Planning Application Ref: **AW/213/18/T**

Location: **7 Willowhale Avenue, Aldwick, PO21 4AU**

Description of works: **Fell 1No. Macrocarpa and crown lift 1No. Macrocarpa to a height of 4.5m**

7 WILLOW HAYLE AVE

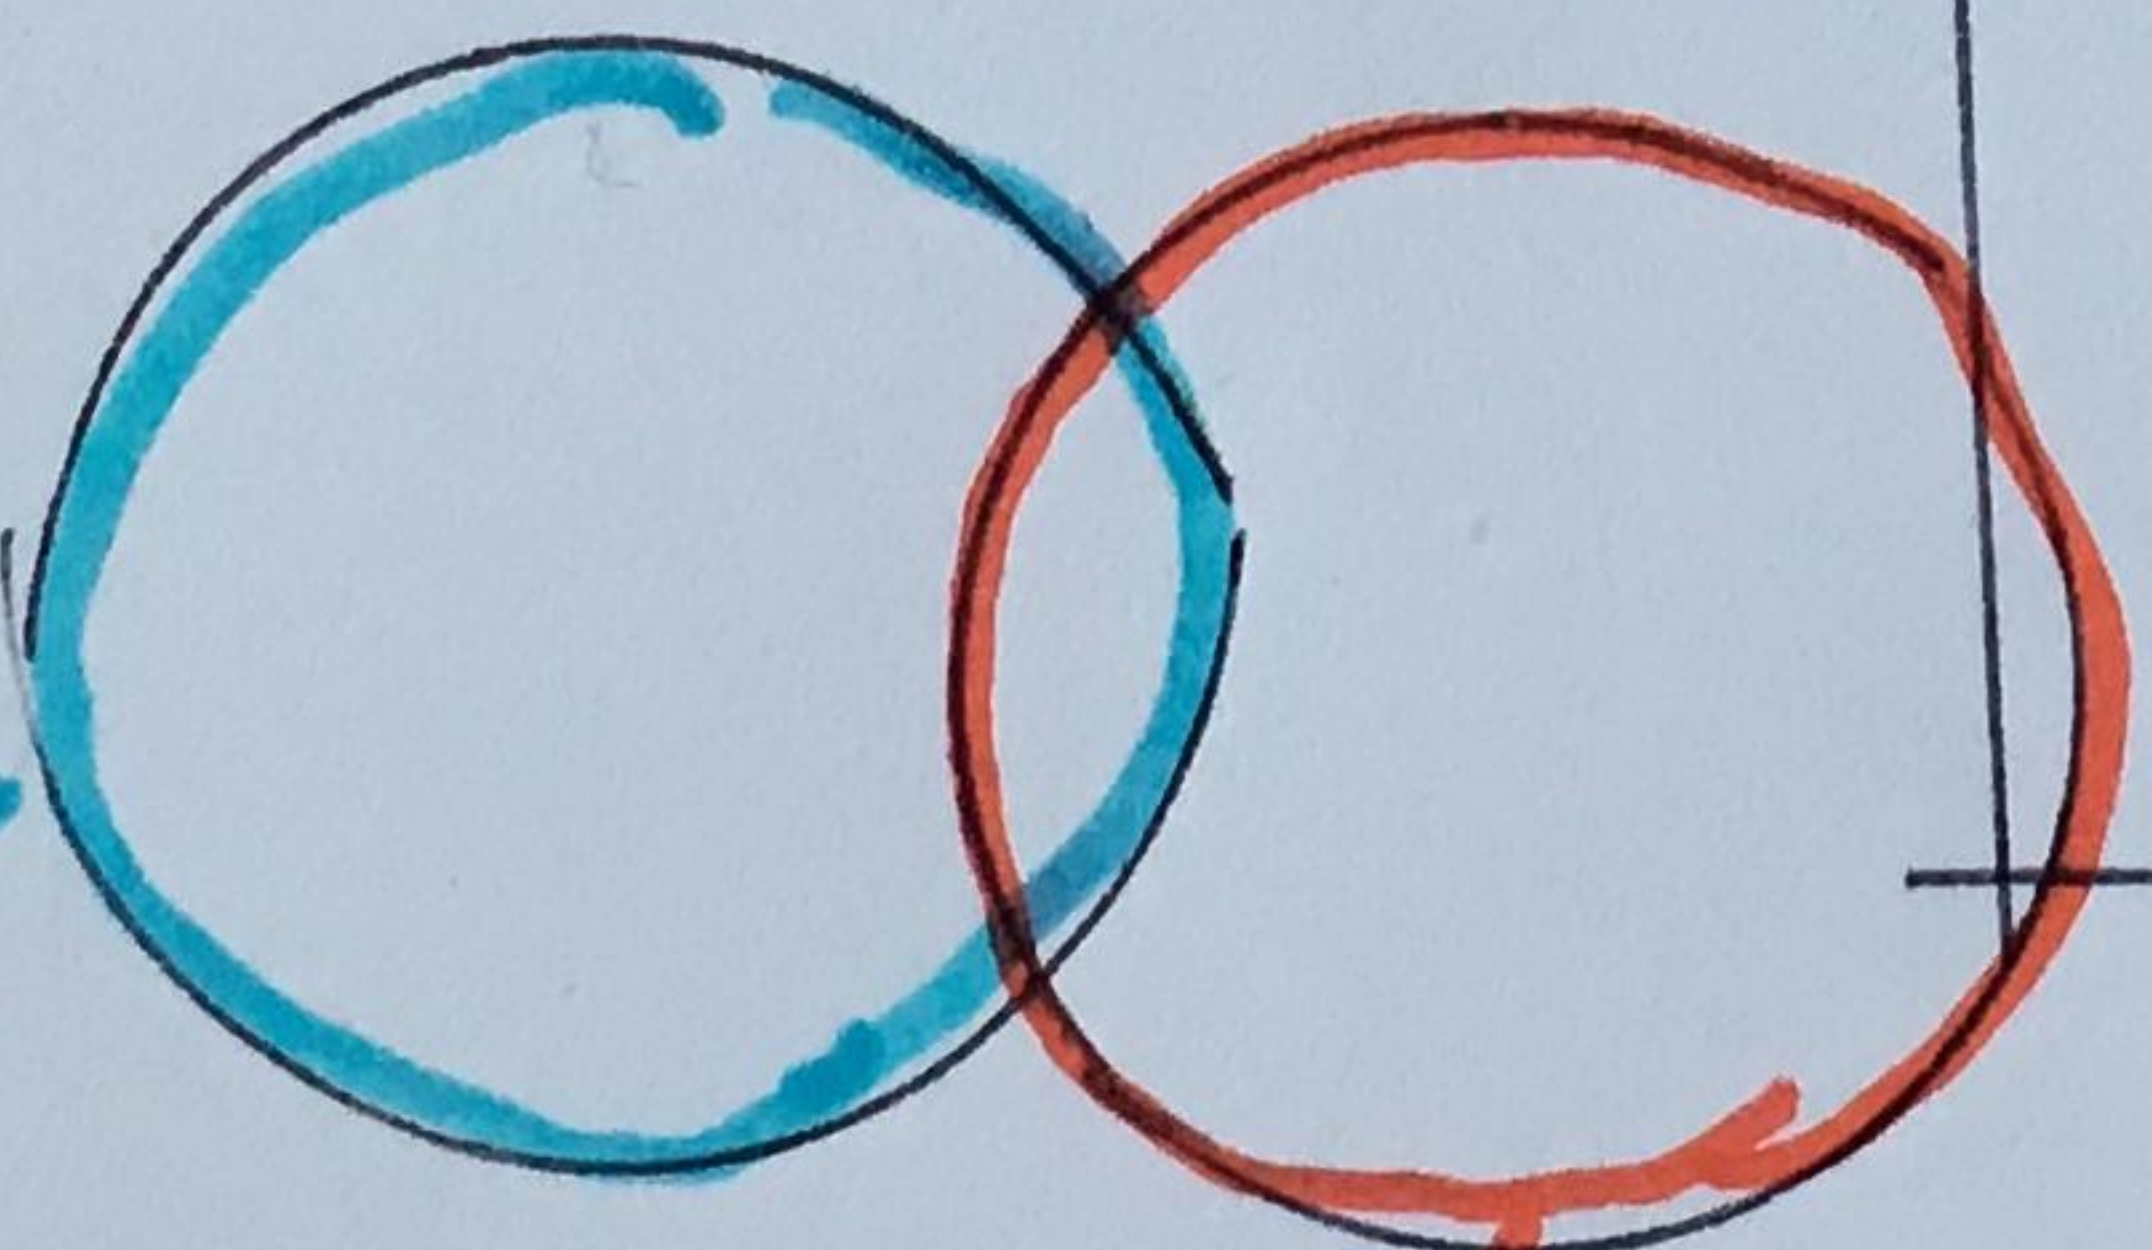
- Both trees appear to be in a fine physiological state, although have distressed form due to past heavy ‘topping’. T1 was previously topped at 5-6m. Contorted growth in response has established in the limb framework and cannot be satisfactorily remediated with pruning. 2 of 3 main stems remain, both of which have areas of decay that while not thoroughly investigated are an obvious cause for some concern. The tree appears stable at ground level but overall has a heavily asymmetric form towards the dwelling.

- T2 is a superior specimen although it too has been topped at around 8metres and has a relatively high number of declining scaffold limbs in the upper crown interior; a not entirely unexpected response to the heavy past topping work.

- T1 is of erratic form with compromised structural integrity and an ‘outlier’ to the horseshoe configuration of the other established garden boundary trees.
- Mature cypress trees grow at uneven spacing along all aspects of the rear garden boundary. As such, to condition a replacement planting on this occasion would be an unreasonable imposition. The removal of T1 will not substantially diminish the visual effect provided by this interesting arboricultural feature. That said, it is likely to be desirable to see replacement tree planting for any successive mature tree removals.
- The works proposed in this application will not result in a notable loss of public amenity value.

- I recommend **CONSENT** is granted for this application, subject to the following condition:
Condition To Be Applied to Approved Work: -
- Where whole branches are to be removed and final cuts made close to the trunk or branch union they are to be made as shown in Figure 2 of BS3998:2010
